A428 Black Cat to Caxton Gibbet improvements

9.88 Schedule of Changes to the Environmental Masterplan

Regulation Reference:	Rule 8(1)(k)
Planning Inspectorate Scheme Reference	TR010044
Application Document Reference	TR010044/EXAM/9.88
Author	A428 Black Cat to Caxton Gibbet Improvements Project Team, National Highways

Version	Date	Status of Version
Rev 1	14 December 2021	Final for Deadline 6
Rev 2	25 January 2022	Final for Deadline 9

Drawing Number
HE551495 -ACM -ELS -
GEN_SW_Z_ZZ_DR-LV-0006

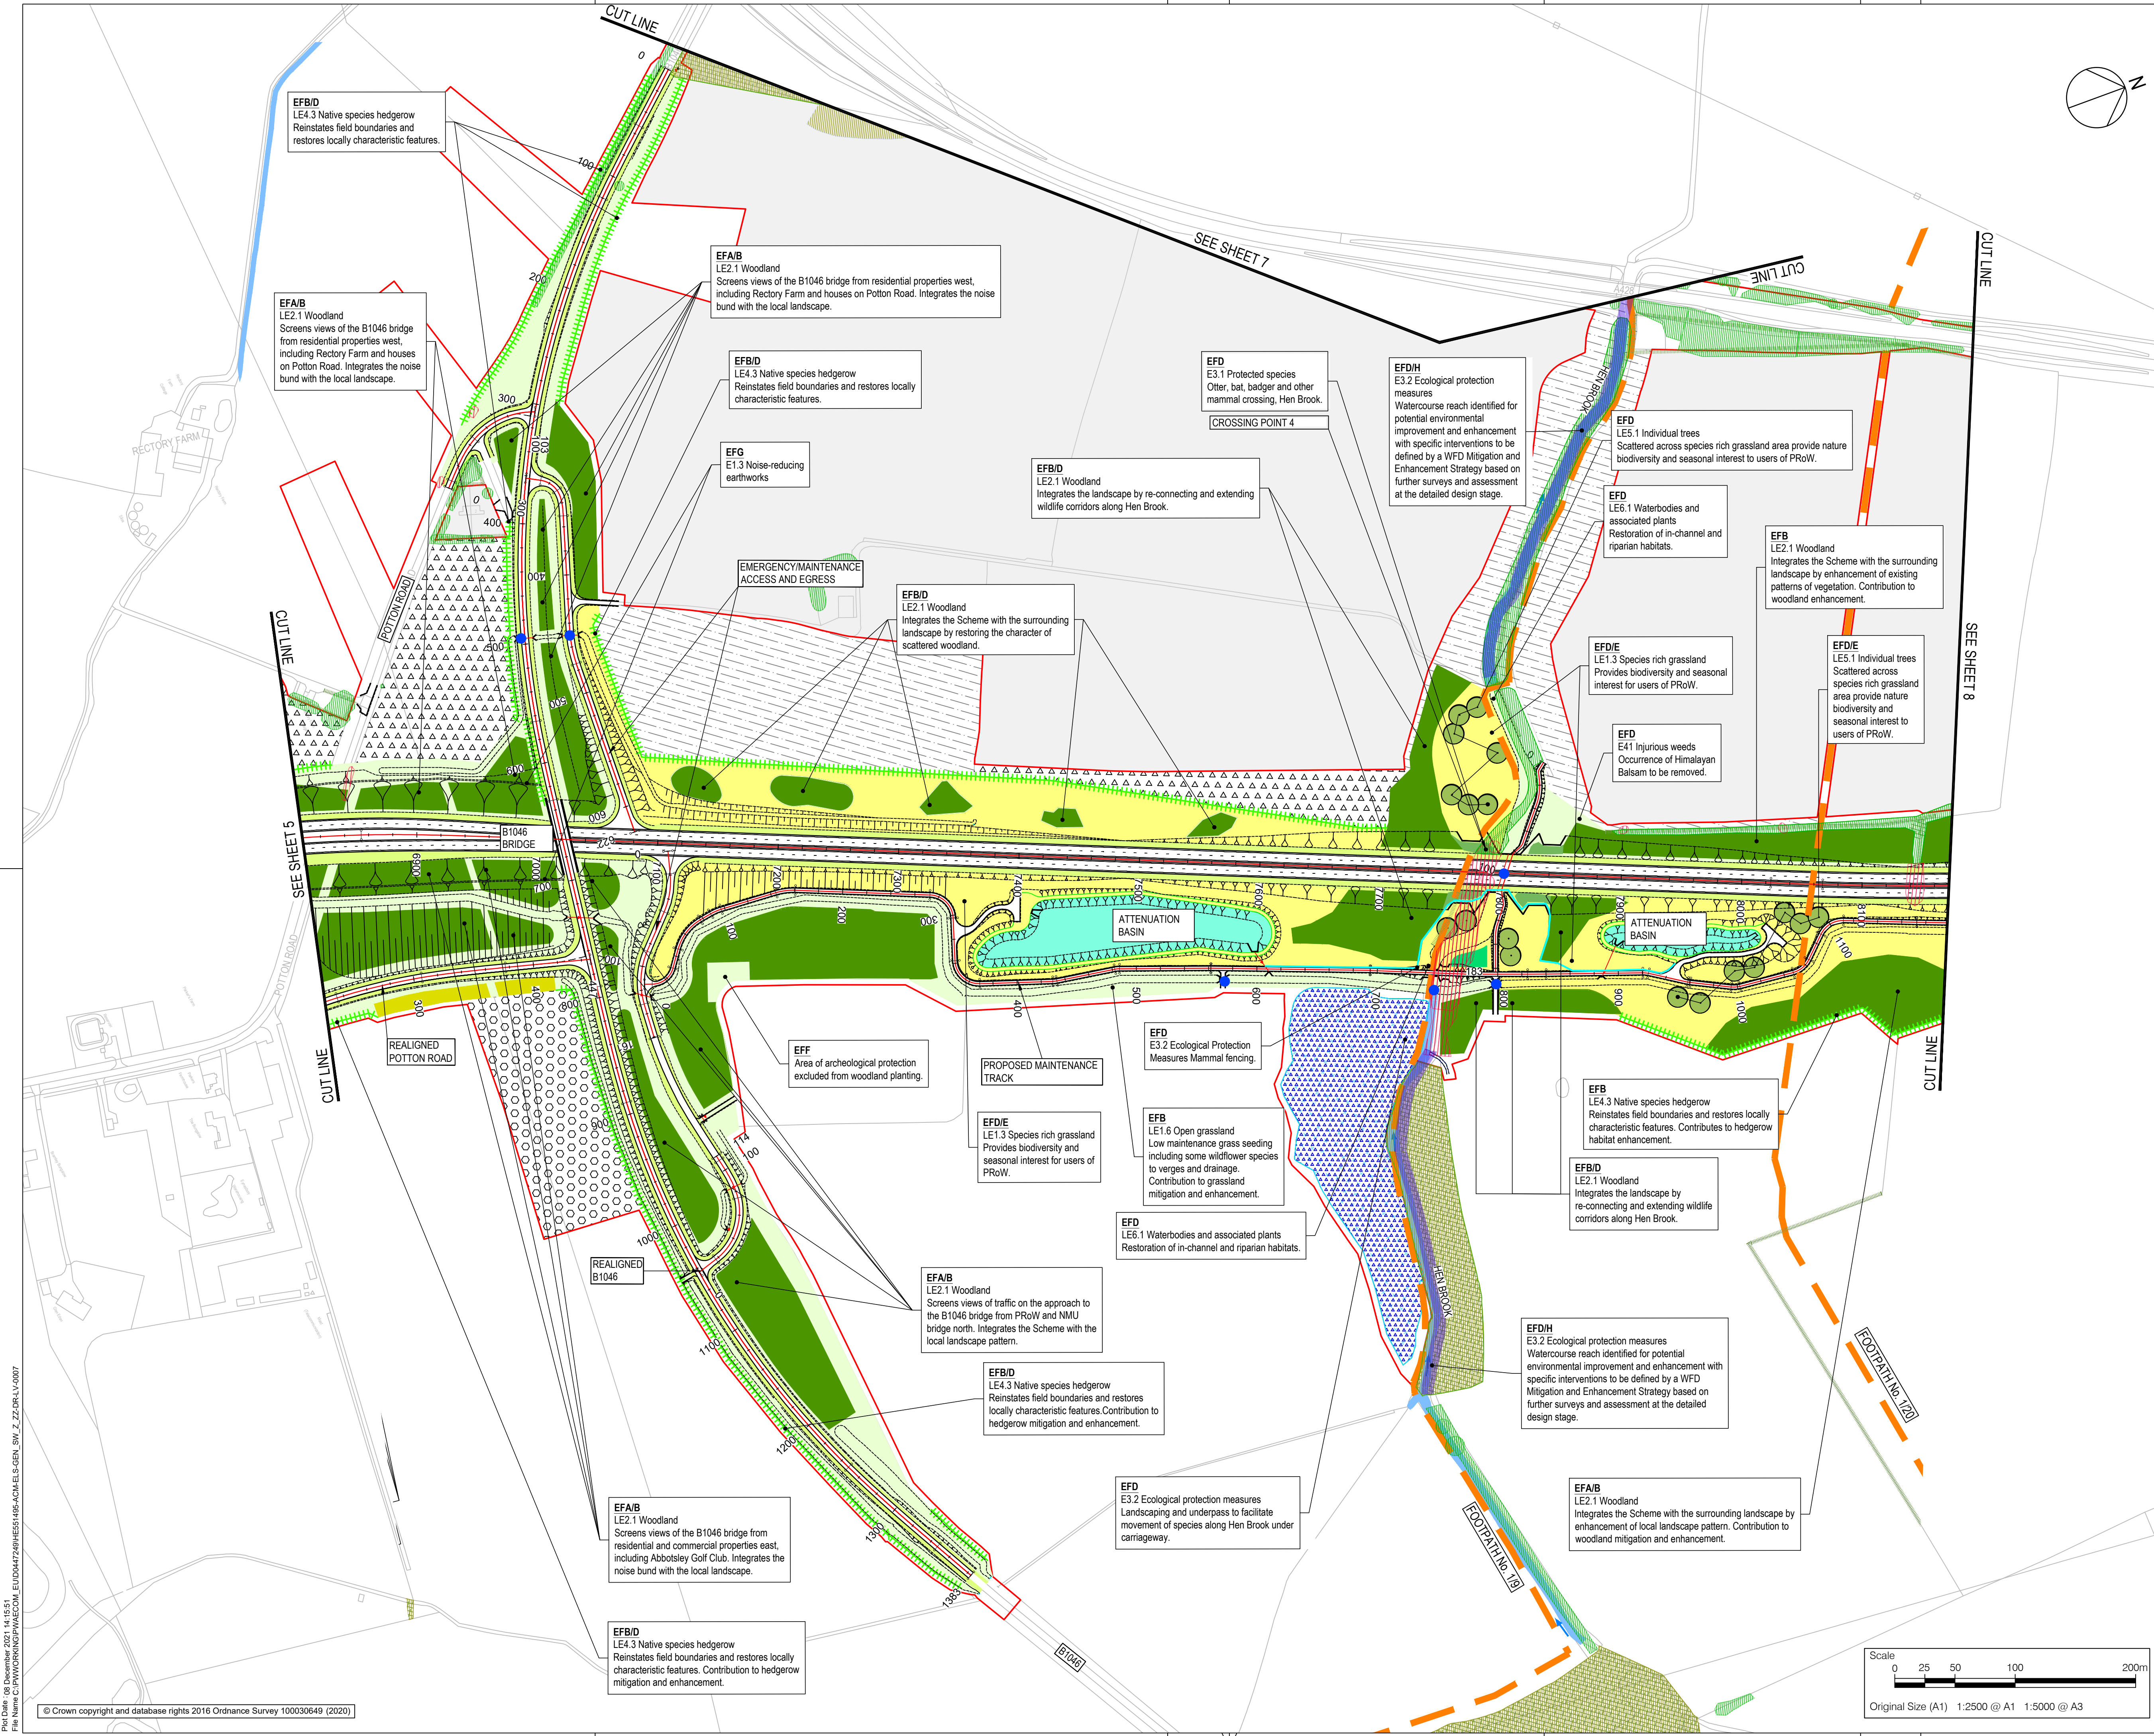
Ref.	Environmental Masterplan page no Ref. with chainage	Consultee	Comments from consultee (Rationale for the change)	Change made	Deadline submitted	Environmental Masterplan Version
		Fragmentation) part a				
7	DR-LV-0006 between chainage 5900 - 6000	Natural England	GCN Mitigation Licence	LE1.3 Species rich grassland Tussocky grass mix as terrestrial habitat for Great Crested Newts.	Deadline 6	Figure 2.4v3
8	DR-LV-0006 between chainage 6600 - 6700	Natural England	GCN Mitigation Licence	LE6.1 Waterbodies and associated plants, pond proposed as receptor site for GCN.	Deadline 6	Figure 2.4v3
9	DR-LV-0010 between chainage 10300 - 10400	Natural England	GCN Mitigation Licence	LE1.3 Species rich grassland Tussocky grass mix as terrestrial habitat for Great Crested Newts.	Deadline 6	Figure 2.4v3
10	DR-LV-0010 between chainage 10200 - 10300	Natural England	GCN Mitigation Licence	LE6.1 Waterbodies and associated plants, pond proposed as receptor site for GCN.	Deadline 6	Figure 2.4v3

Drawing Number: HE551495	ACM	ELS	P02
Location: GEN_SW_Z_ZZ	DR-LV	-0011

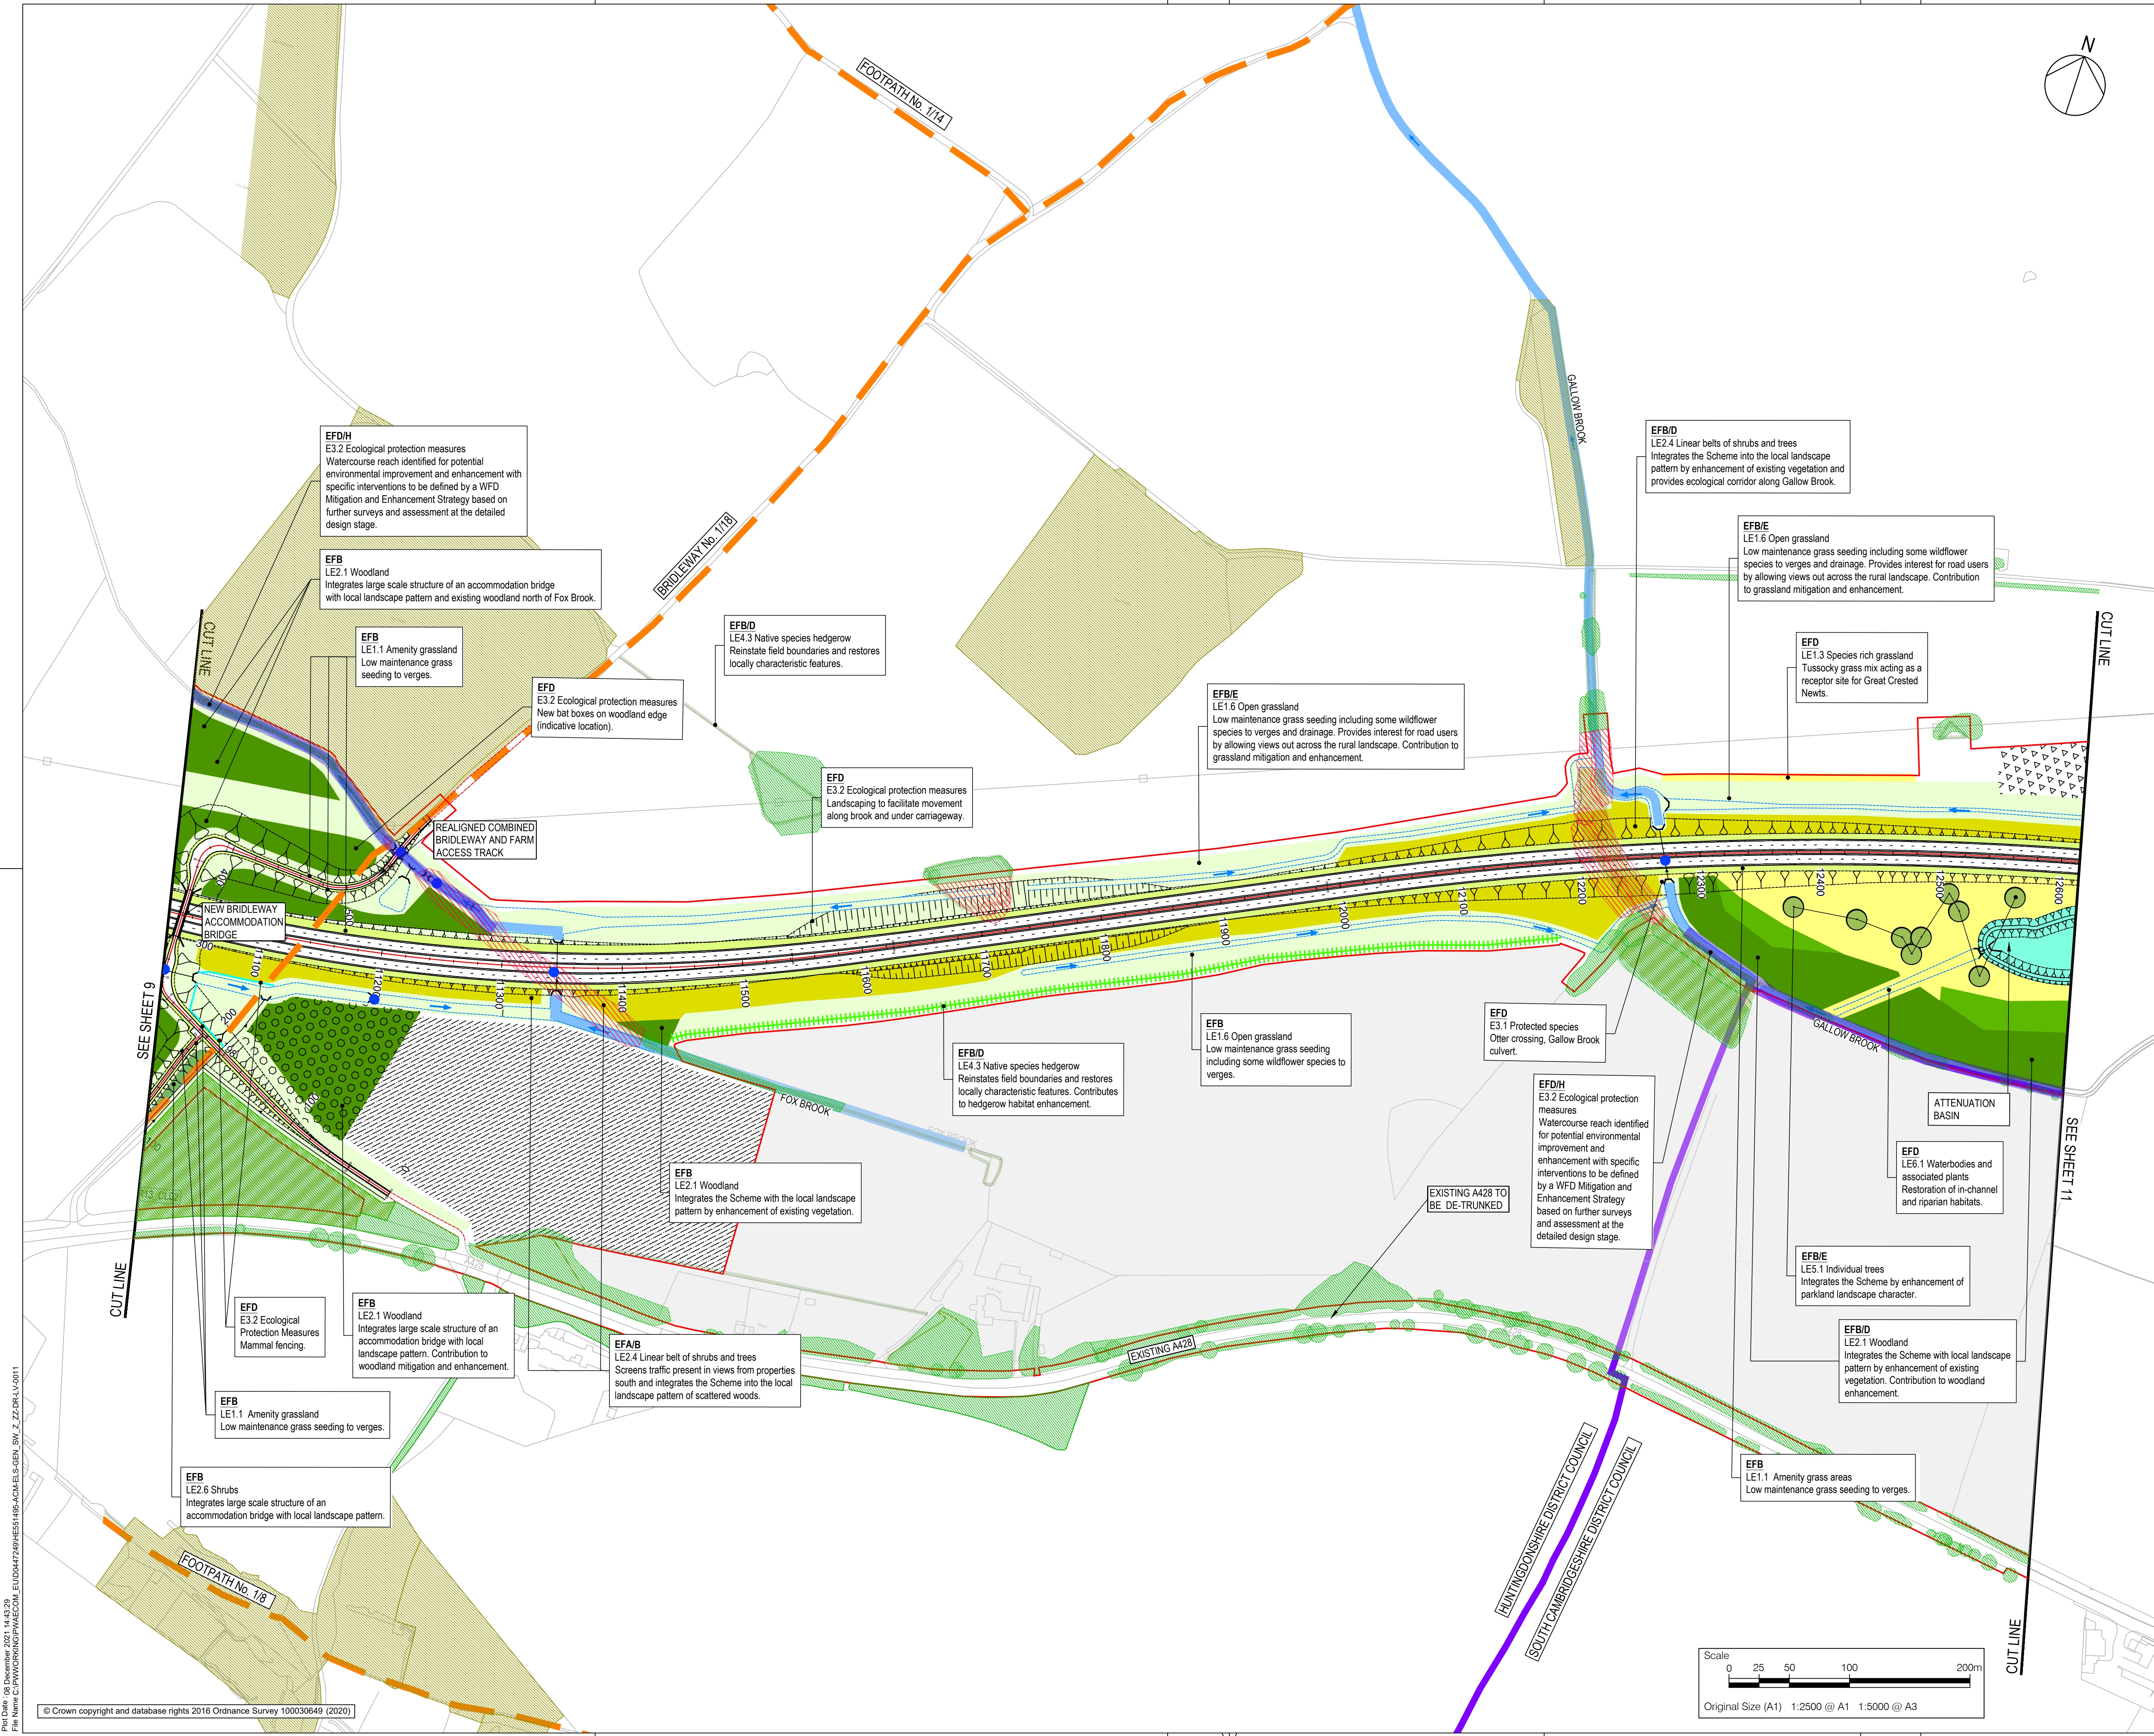
11	DR-LV-0011 between chainage 12300 - 12400	Natural England	GCN Mitigation Licence	LE1.3 Species rich grassland Tussocky grass mix as terrestrial habitat for Great Crested Newts added.	Deadline 6	Figure 2.4v3
